Powerhouse Ultimo Revitalisation

Application Number SSD-67588459
Assessment Type State Significant Development
Development Type Museum, Gardens & Zoos
Local Government Areas City of Sydney
Exhibition Start-End Date 03/05/2024 - 30/05/2024
Contact Planner Name Annika Hather

30 May 2024

Figure 26 Proposed materials and façade finishes.

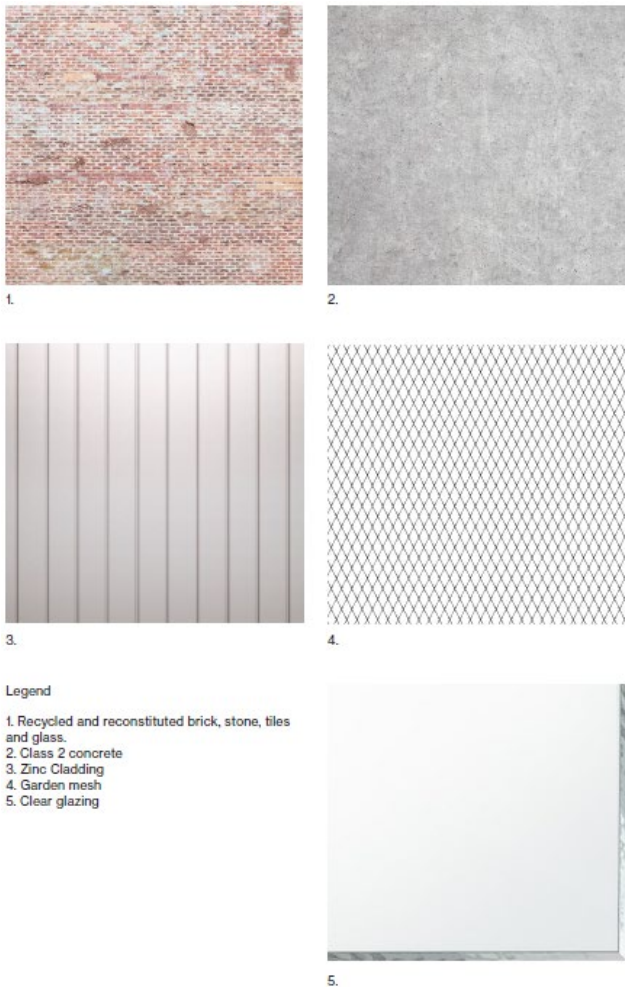
Design principles developed and guidelines for this 'renown' project do not include bird safe design. Rather, proposed materials and façade finishes are clear glazing, not bird safe glazing.

The Design Response has through views for birds. Birds cannot recognise daylight reflections and glass does not appear to them to be solid. If it is clear they see it as the image beyond the glass.

Figure 39 Modelled view from 537 Harris Street

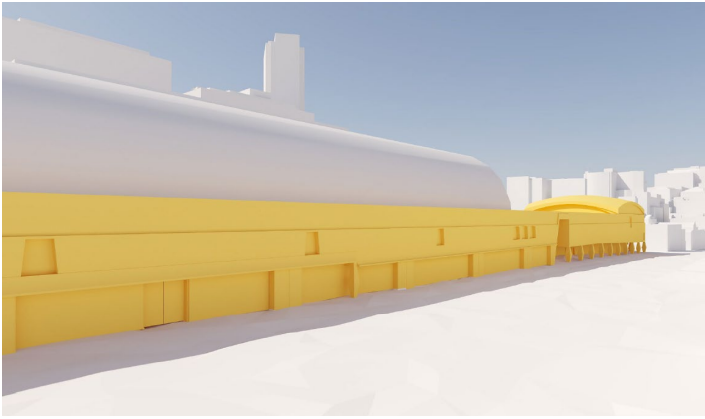
People appear in the images to be sheltered to walk and gather, then as they approach the William Henry cross Harris Street end of the Powerhouse, there is no or very thin shelter. Where is the safety from the road for all ages and abilities?

Considering the vast number of coaches drop off/pick up proposed for Harris Street, this design has all the more convincing reason for the full 75m of the Powerhouse on Harris Street to have appropriate width awning/cover.

Figure 48 Construction routes for the site

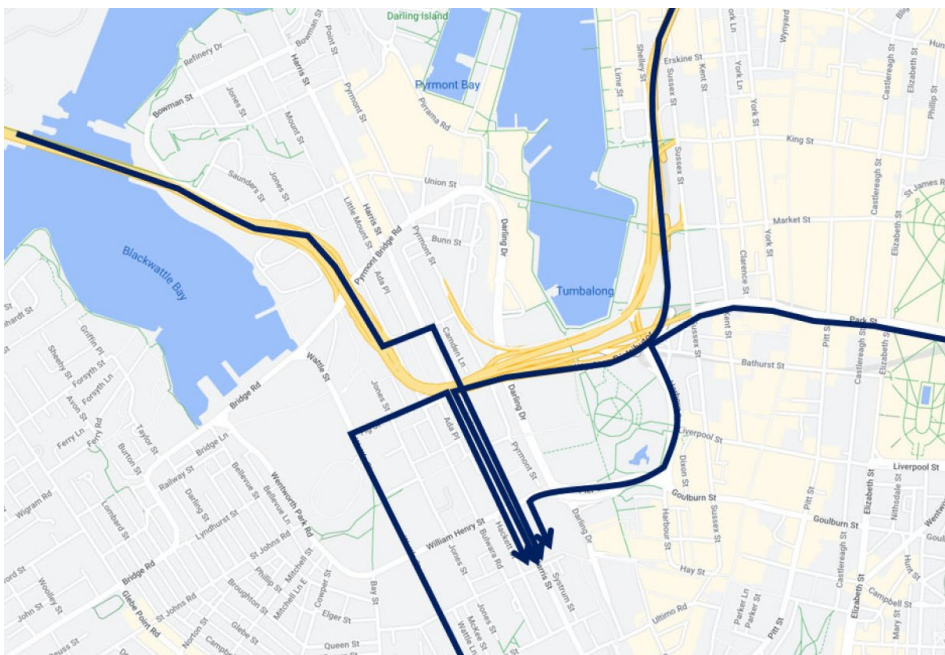
Please note, haulage routes and Native wildlife, Currawongs, Magpies, Ravens and Kookaburra's currently have active and skeleton nests in street trees at several locations along Harris Street. These trees need extra protection, toolbox inductions, documented management plans for extra-large/high construction vehicles being moved in/out for this build. Works may exceed the whole duration of Spring / Summer, bird breeding times.

Excellent to see a list of State nearby development projects. There is a significant amount of works happening/ soon to happen across the immediate area. For future documentation work by Ethos Urban, will EIS contractors add critical relevance to the Cumulative impacts list for both Assessors and Community by the inclusion of an extra column in the Table, titled 'Haulage Route'. Where the EIS Cumulative impacts can state clearly 'An assessment of the haulage route for e.g. Harbourside Shopping Centre, overlapped with the haulage route for the Powerhouse Museum is under the relevant EIS Section? Table? Haulage Route A (blue) for Harbourside Shopping Centre Redevelopment...etc. By the inclusion of this column in a EIS description, there will be haulage route transparency. Assessors this EIS does not clearly state if current haulage routes will be used for this build?

Figure 51 Proposed trees for removal noted in red

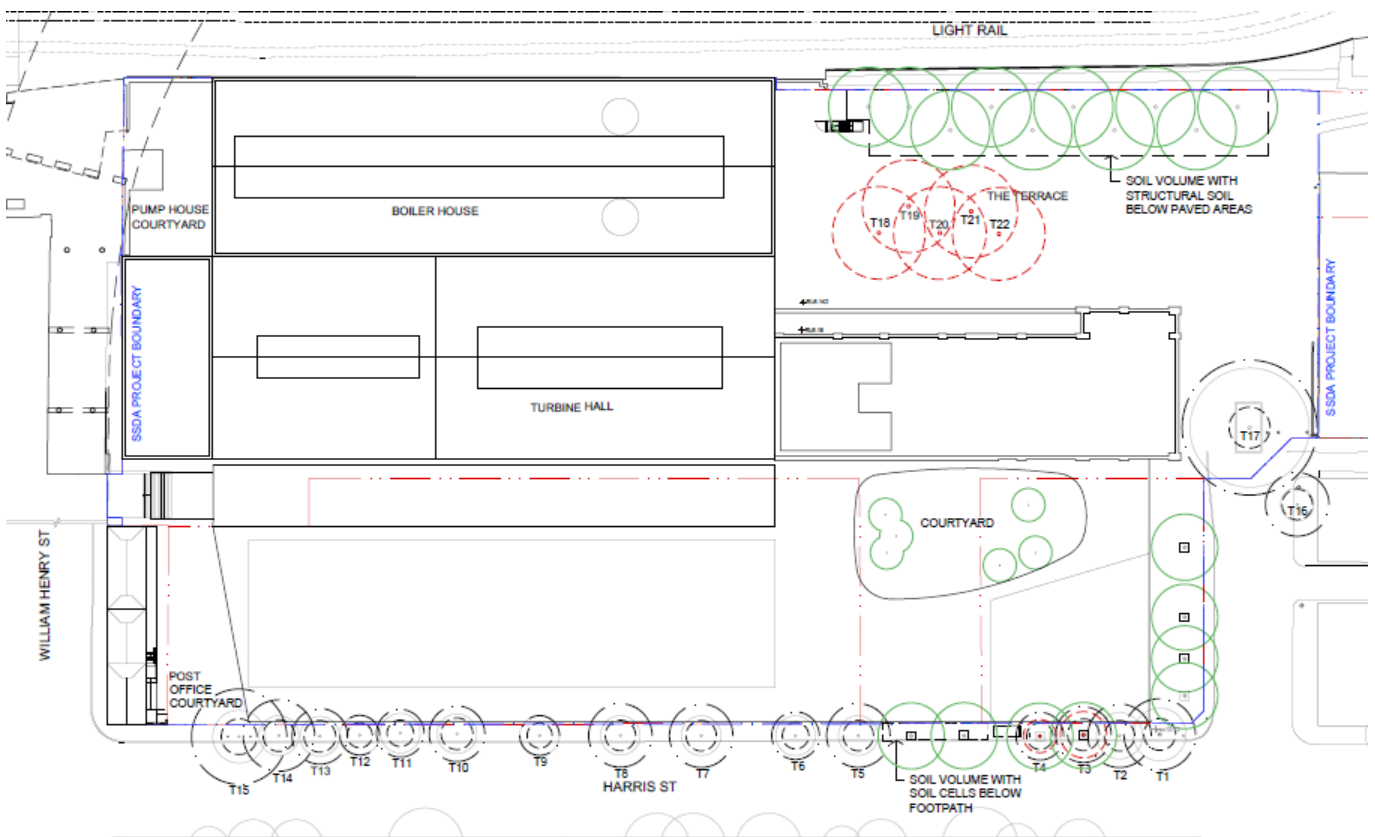
Should tree removal be scheduled for mating, egg sitting season, chicks hatching, learning to fly season and arborists remove or do hard pruning of large trees. Active birds' nests should not be removed or the adult birds scared off. One adult bird could be sitting on eggs, while the other adult bird gathers and returns with food. Or feeding young. A full assessment of the trees close to work zones, haulage routes and park land impacted by construction vehicles and storage areas should be carried out with a representative from WIRES. The Pymont WIRES volunteer worker would also complete a thorough examination (dawn and dusk) of all the trees (all sizes) for skeleton and in use birds' nests.

Currently there is a vast number of different native birds in Ultimo with less and less large tree, these native birds and their nests need to be protected. The proposed Biodiversity Development Assessment Report waiver would literally have contractors come in at any time of the year and remove large trees without each tree being detailed/assessed for new bird nests being built and importantly active birds' nests in trees with adult birds sitting on eggs, or chicks with an adult in the nest when another adult is gathering food.
